Our Case Number: ABP-312131-21

Re: Greater Dublin Drainage Project consisting of a new wastewater treatment plant, sludge hub centre, orbital sewer, outfall pipeline and regional biosolids storage facility
Townlands of Clonshagh, Dubber and Newtown, County Fingal and Dublin City

RE: Case No. PA06F.312131 – Greater Dublin Drainage Project

Drawing No.: Drawing No. 10

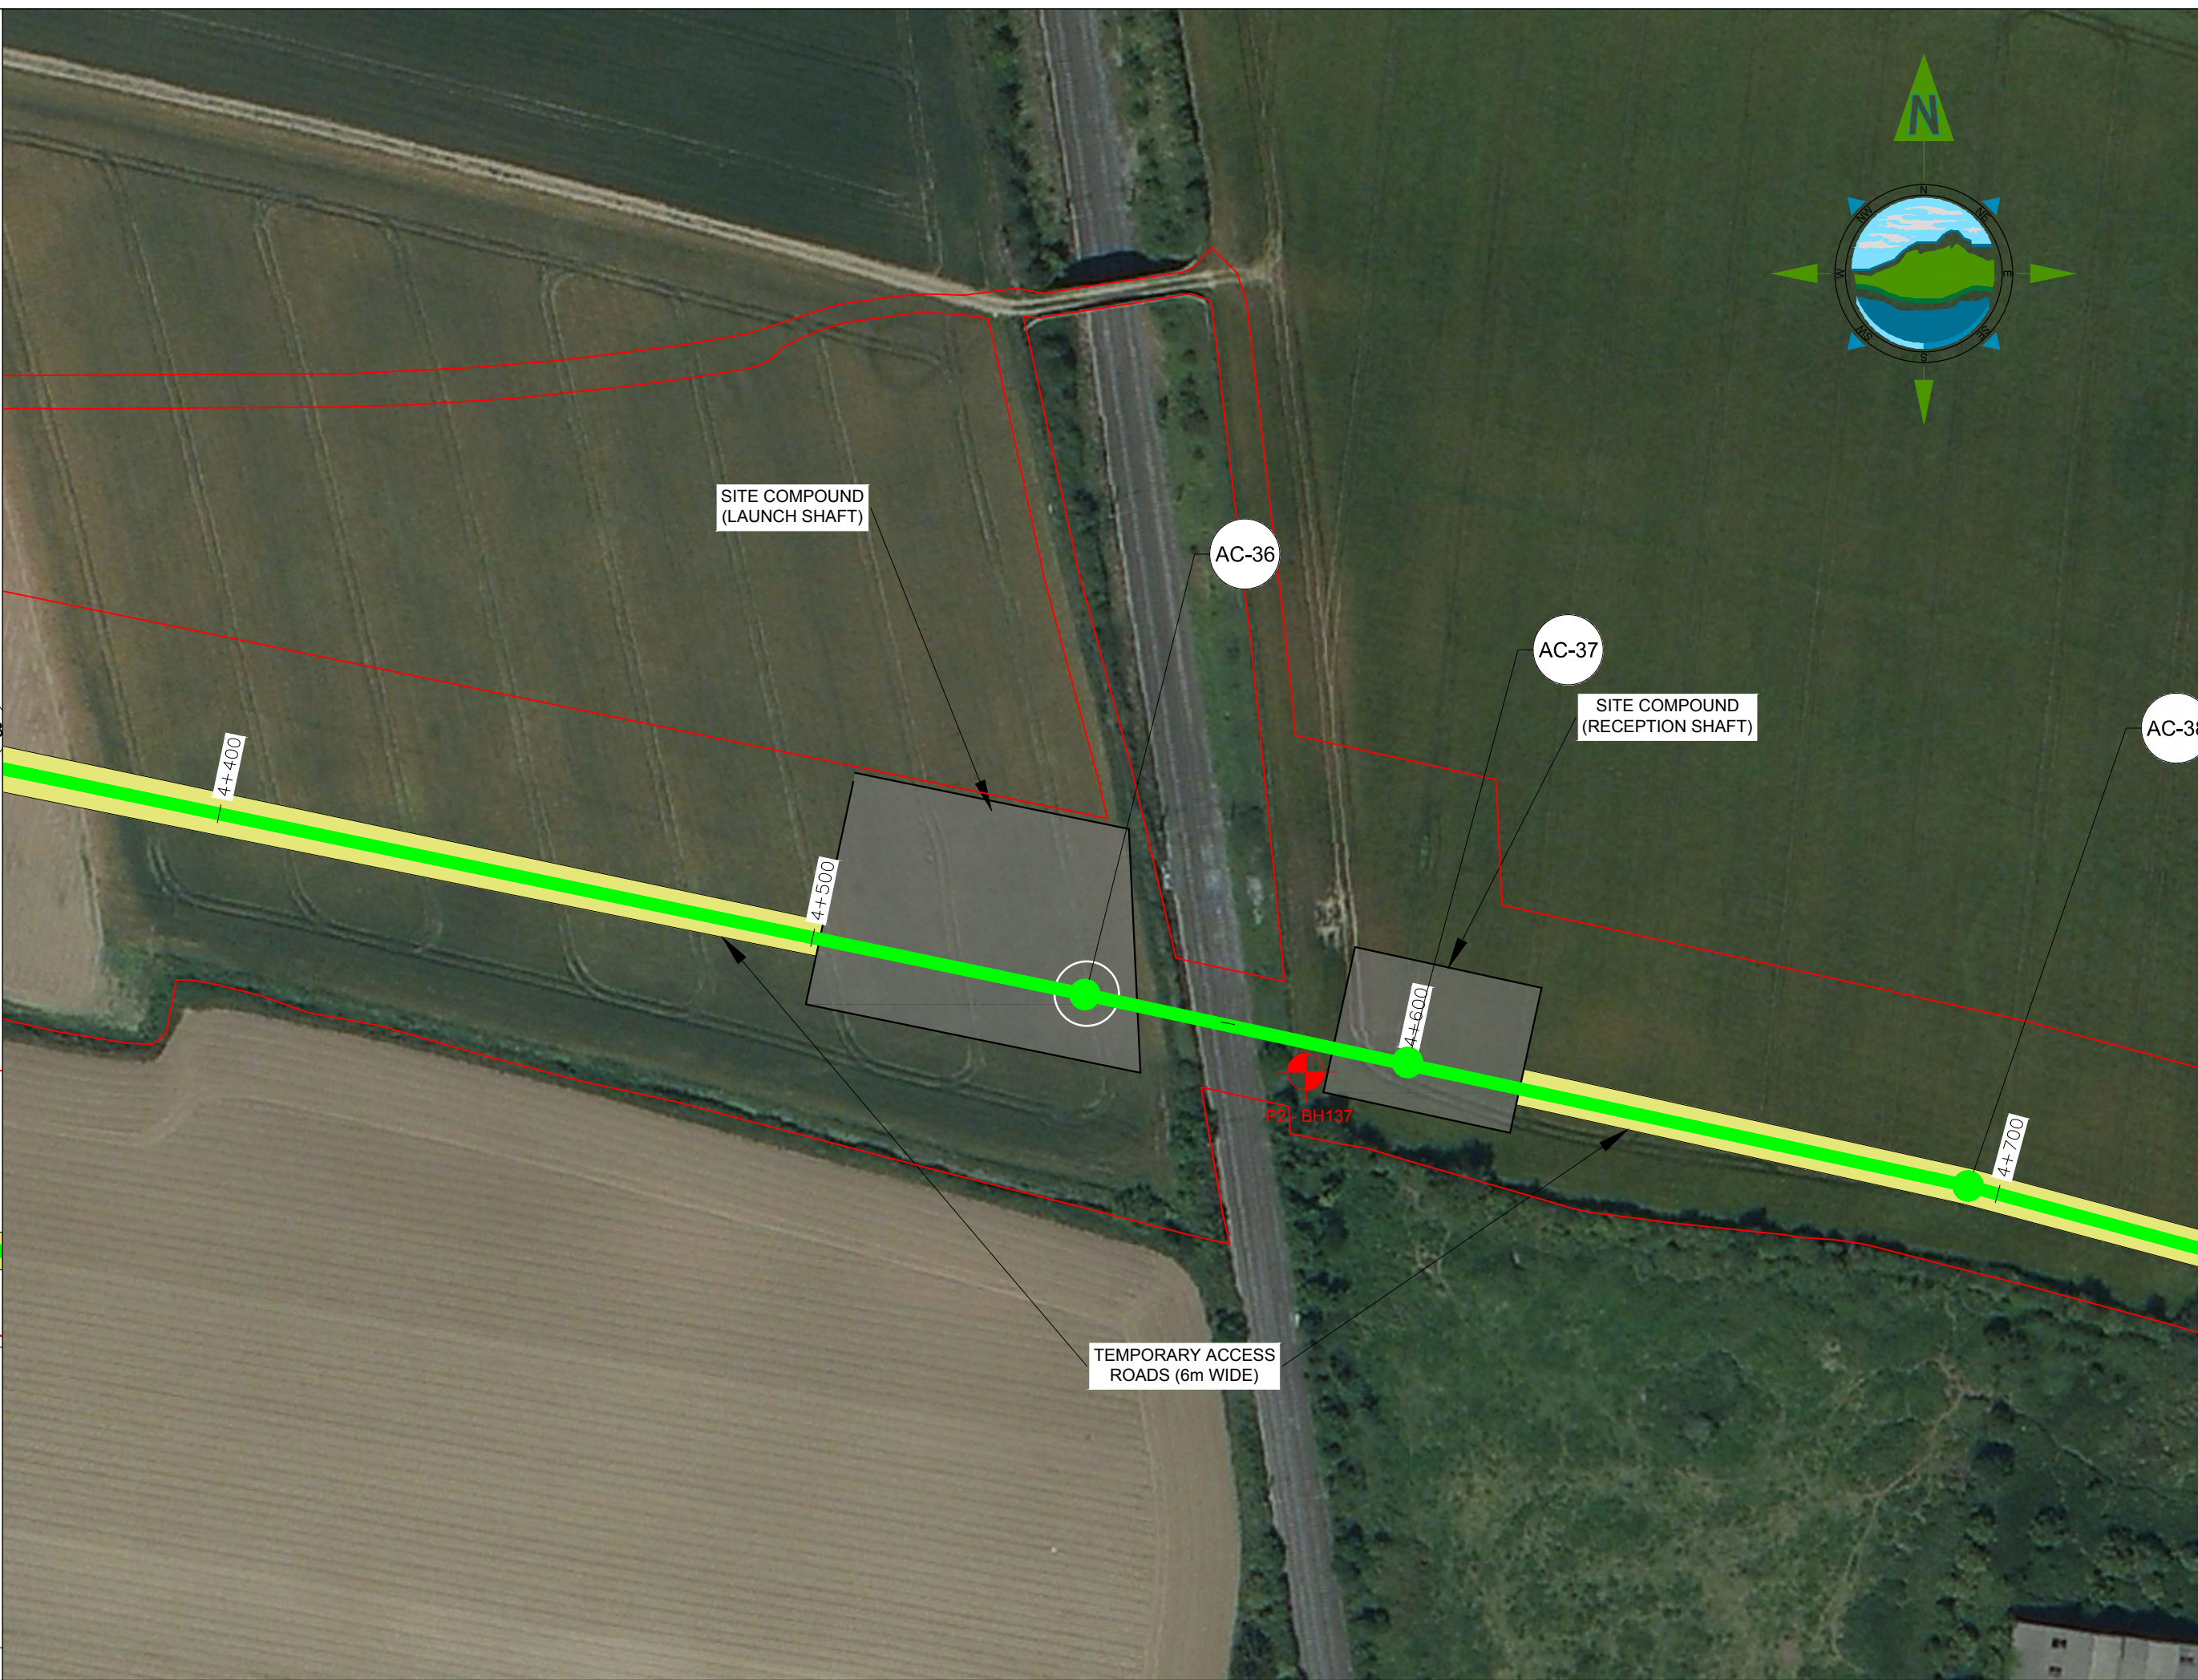
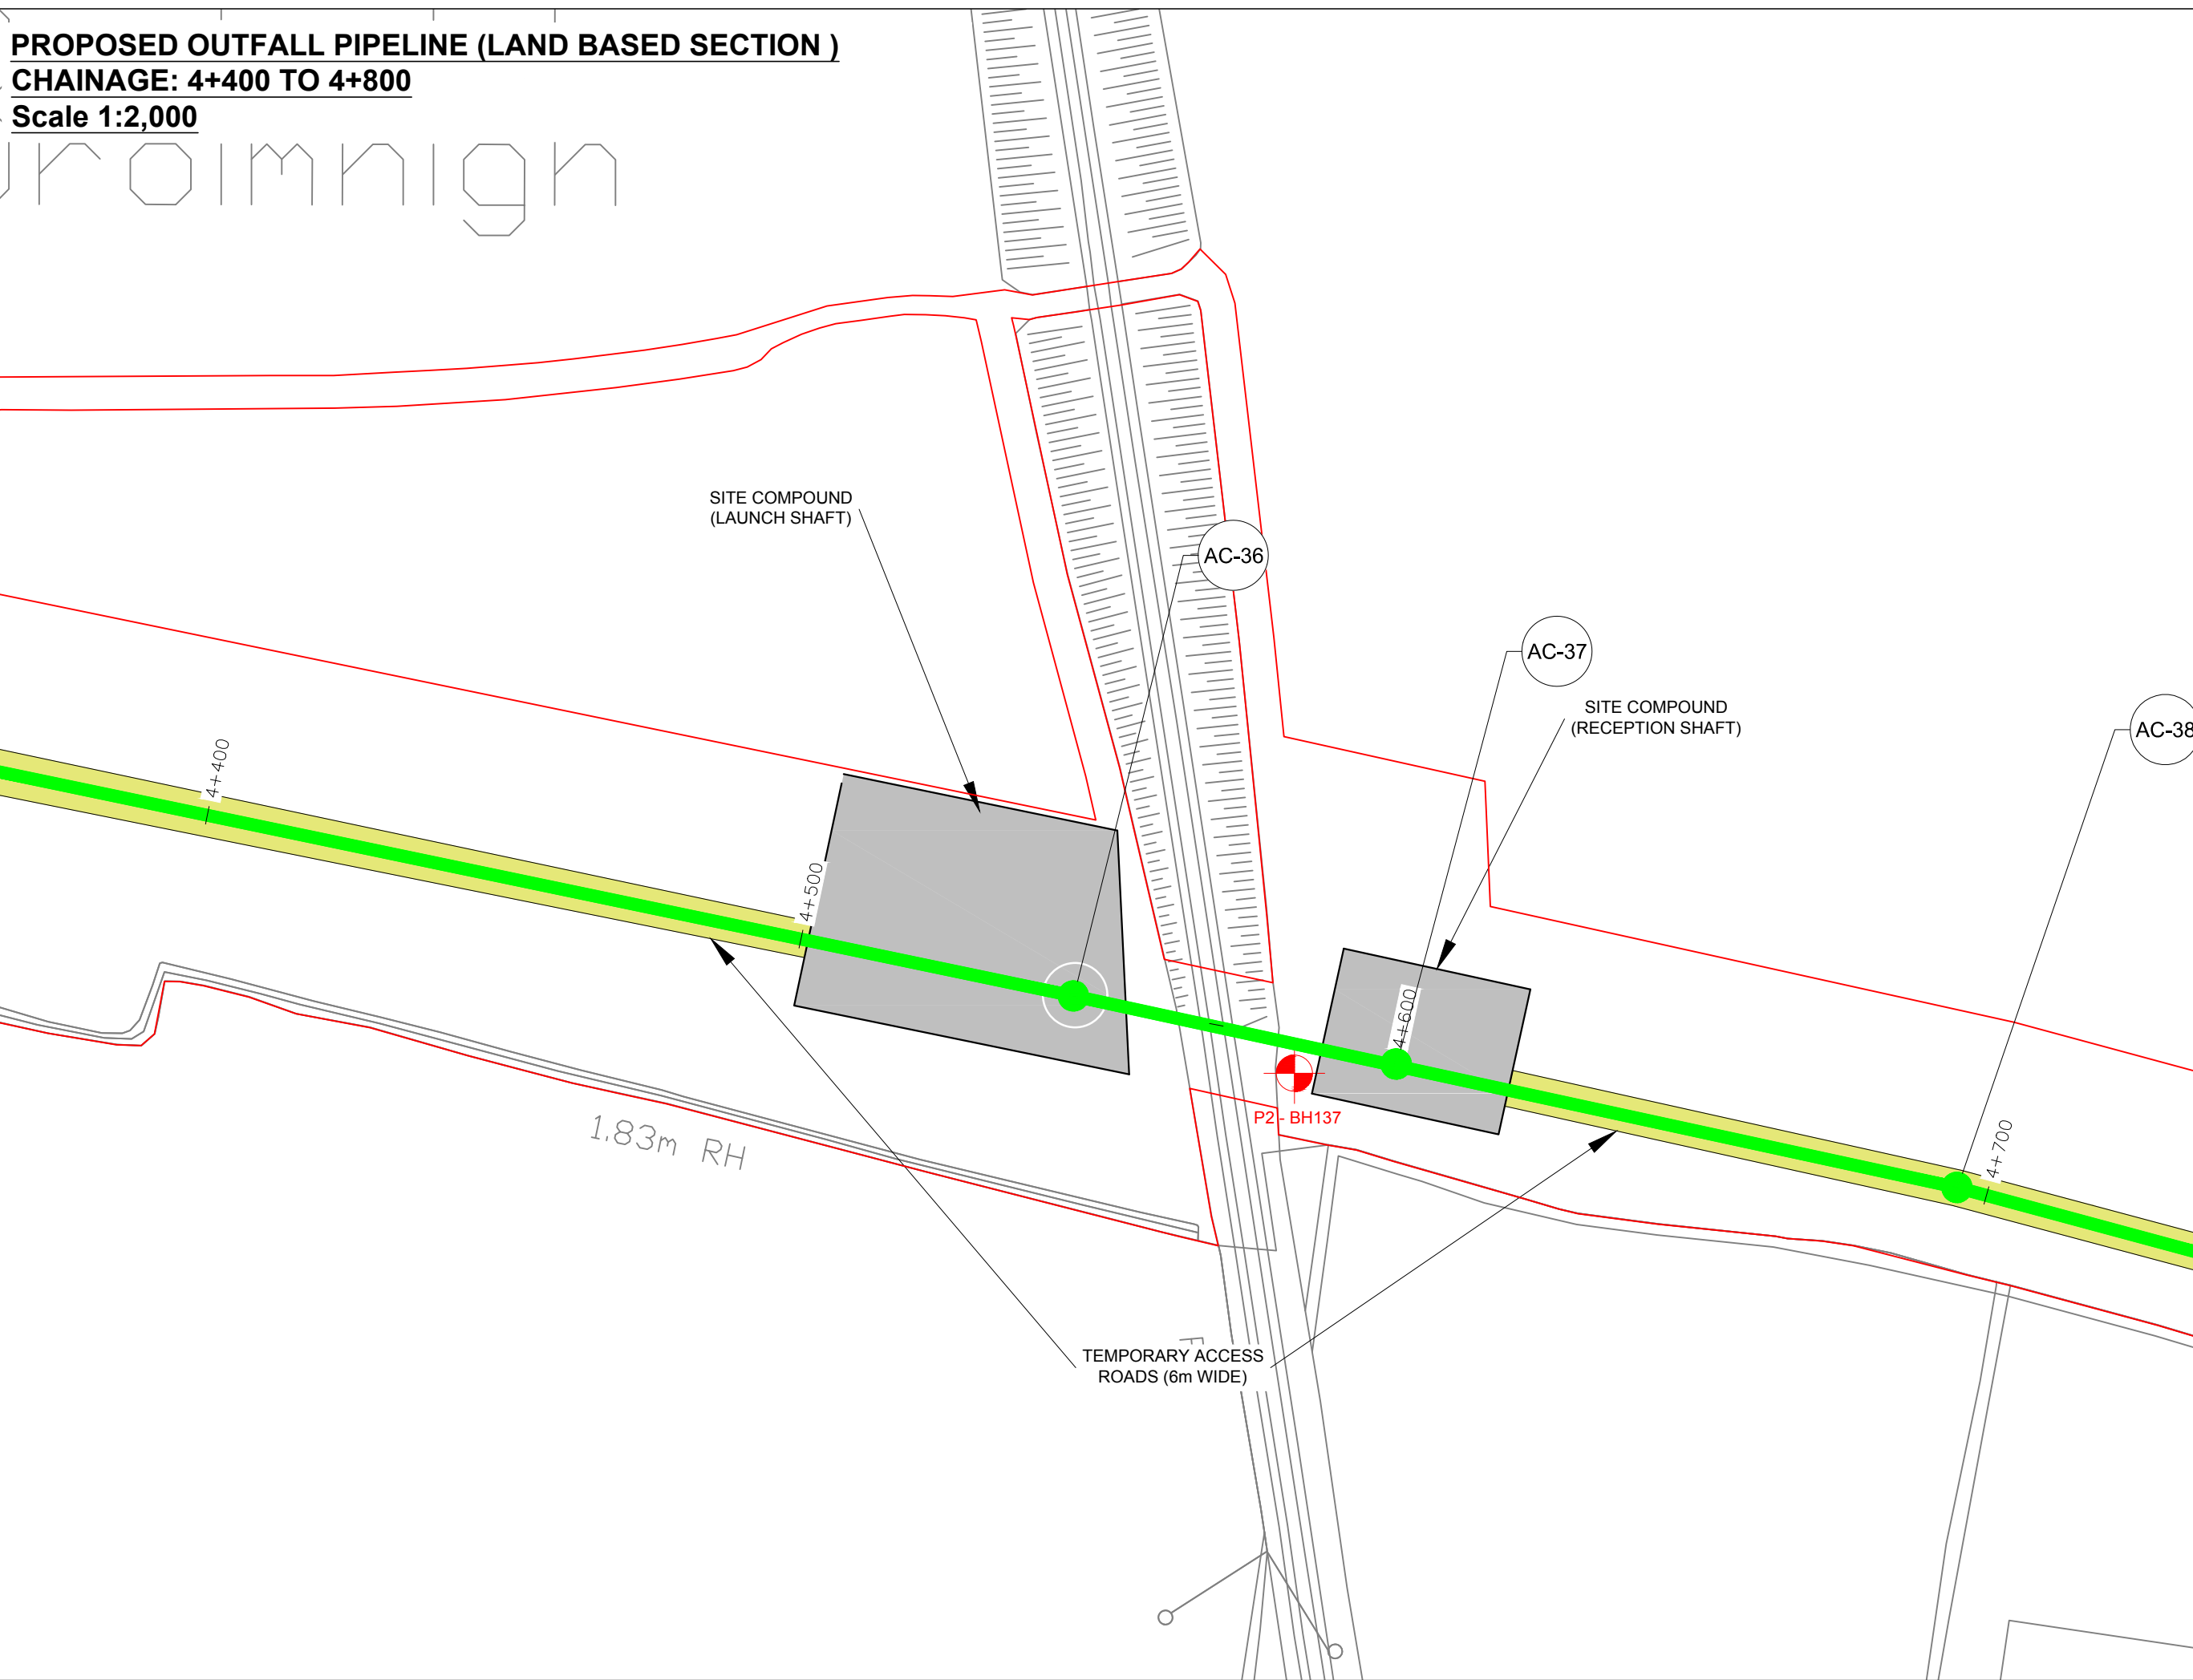
Having reviewed the proposed documentation submitted as part of the GDDP application, the NTA would request that the following documents are updated to accurately reflect the Metrolink scheme as per the application lodged:

- Appendix A4.2 – Engineering Specialist Report for Crossings, Section 3.3.3 and Drawing 10 [Appendix A4.2 Engineering Specialist Report for Crossings.pdf \(pleanala.ie\)](#).
- Environmental Impact Assessment Report Volume 2 Part A of 6 Chapter 4 Description of the Proposed Project [Chapter 4 Description of the Proposed Project.pdf \(pleanala.ie\)](#) as updated in [Chapter 4A Description of the Proposed Project \(pleanala.ie\)](#) – The EIAR should be updated to reference the proposed MetroLink project.
